WEST SUSSEX COUNTY COUNCIL CONSULTATION

TO:	Arun District Council FAO: Zac Denton
FROM:	Highways, WSCC
DATE:	06/02/2019
LOCATION:	Worthing Road Allotments, Worthing Road, Littlehampton
SUBJECT:	LU/334/18/PL Extension to existing allotment site
DATE OF SITE VISIT:	N/A
RECOMMENDATION:	☒ Advice ☐ Objection ☐ Modification ☐ No Objection ☐ More Information ☐ Refusal
S106 CONTRIBUTION TOTAL:	£N/A

CLA.04
Rev B

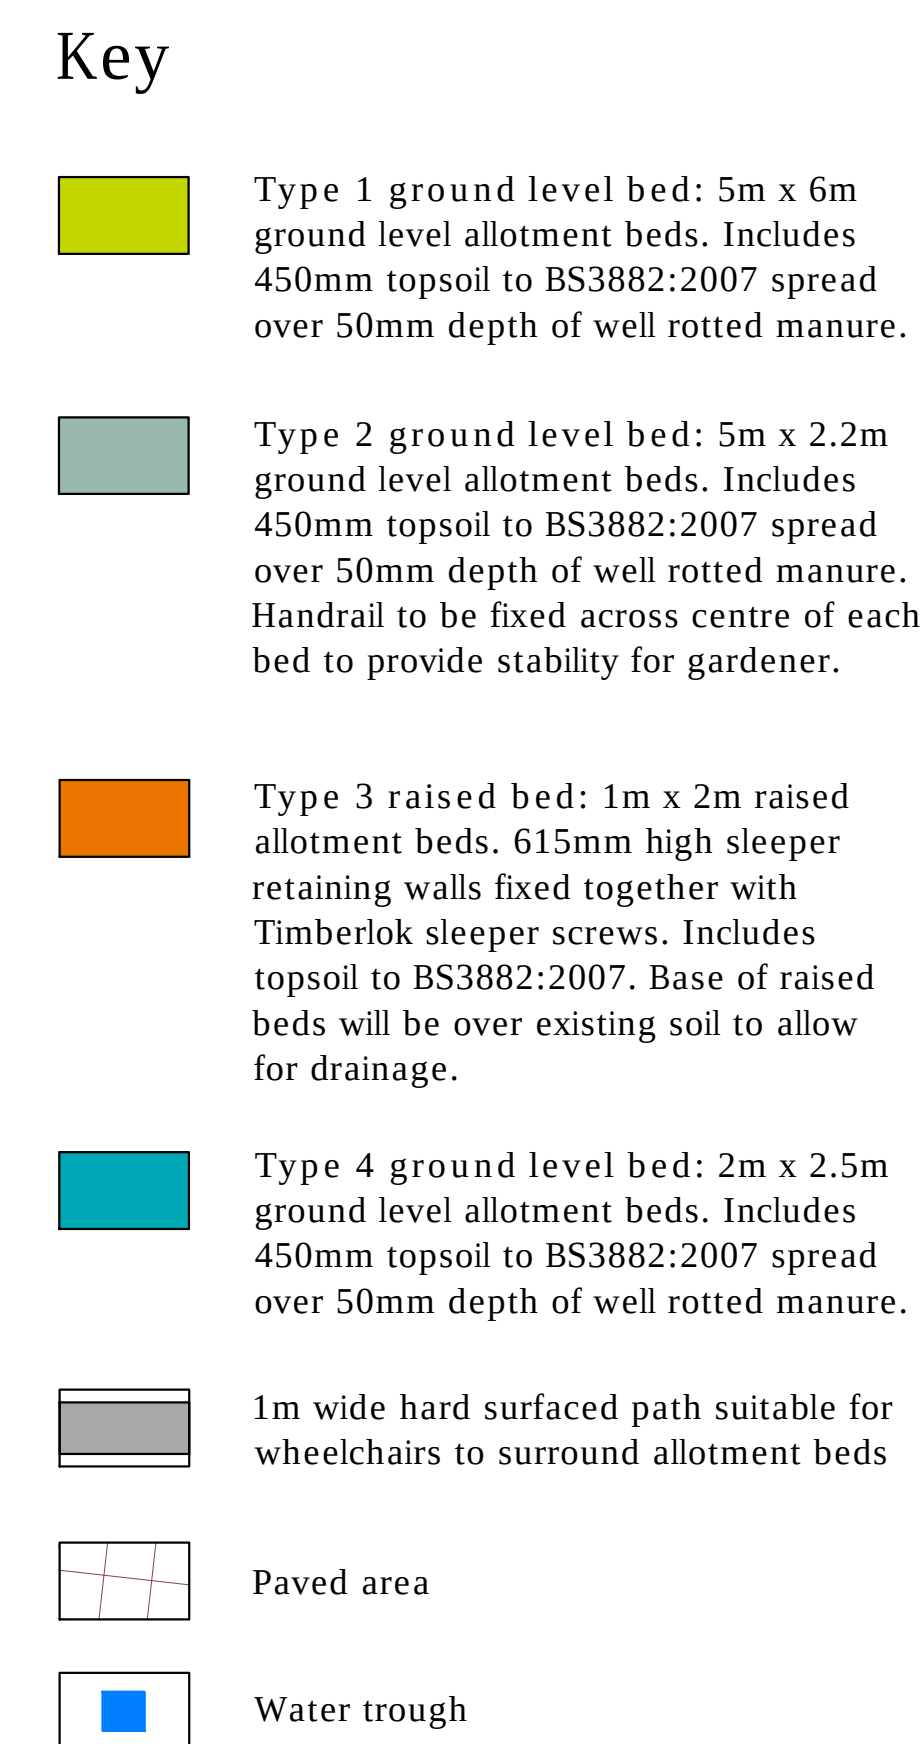
The application form states that 10 parking spaces will be provided on site for the additional allotments. The proposed plan indicates that 6 formal accessible parking spaces will be provided. These spaces meet minimum specifications as set out in Manual for Streets (MfS). The proposed plan does not indicate whether these spaces will be reserved for disabled users or for use by all visitors to the site. An additional parking area is proposed on site, which scales off to 1:250. This proposed parking area will provide additional parking for up to two vehicles according to MfS specifications of 2.4 x 4.8m per parking space, providing a total on-site provision of 8 spaces. WSCC does not publish Parking Standards for allotment use, however, should the proposed accessible spaces be reserved for disabled users only, this may result in overspill parking onto the nearby public highway. Whilst on-street car parking is limited in the immediate vicinity there are comprehensive parking restrictions prohibiting vehicles from parking in places that would be detrimental to highway safety. We would not consider that highway safety would be detrimentally affected through the proposed car parking provision. The Planning Authority

Whilst manoeuvrability space appears restricted, there appears to be sufficient space for vehicles to turn on site via a multi-point manoeuvre, enabling vehicles to exit onto the publically maintained highway in a forward gear.

Car parking space (details approved)

No part of the development shall be first occupied until the car parking has been constructed in accordance with the approved site plan. These spaces shall thereafter be retained at all times for their designated purpose.
